PLANNING CONSULTATION RESPONSE

Application No	2026/0298
Proposal	Change of use of upper floors from storage to create 3x flats (Use Class C3) including conversion of roof space and installation of rooflights.
Address	36 Hoyland Road, Hoyland Common, Barnsley, S74 0PB
Date of Consultation Reply	29 th May 2026
Consultee	Highways DC

Proposed site plan
Scale: 1 : 200

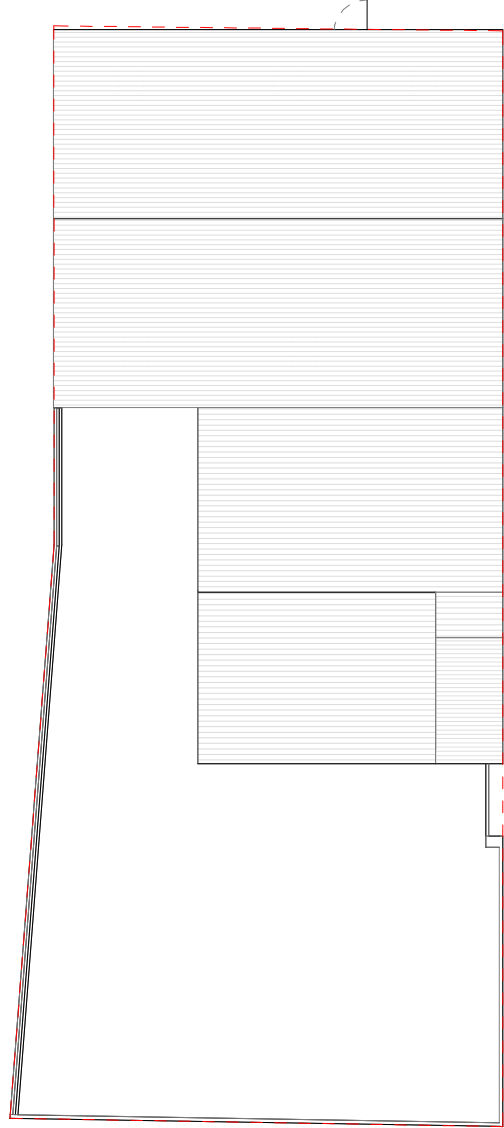
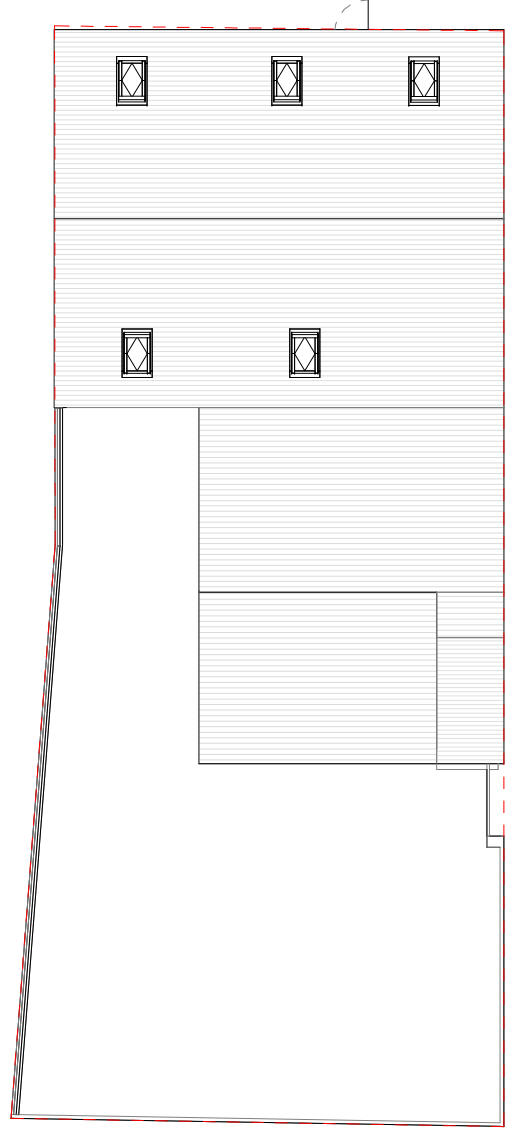
The site layout plan shows that the proposals include the provision of three off-street parking spaces within the rear yard area which is accessed from Hoyland Road via a covered passageway. Given that the access and rear parking area are existing facilities, it would appear that the proposals result in the loss of off-street parking provision for the existing ground floor Office use; further information should be provided in this regard.

The site access is substandard in terms of being able to achieve the required 2m x 2m pedestrian visibility splays to the rear of the footway along Hoyland Road and is therefore unsuitable for any intensification of use; it should be demonstrated that the proposals do not result in an increase in vehicular movements along the access.

The applicant should also note that each parking space must have minimum dimensions of 5m x 2.5m and that adequate manoeuvring room should be provided so that vehicles may turn within the site.
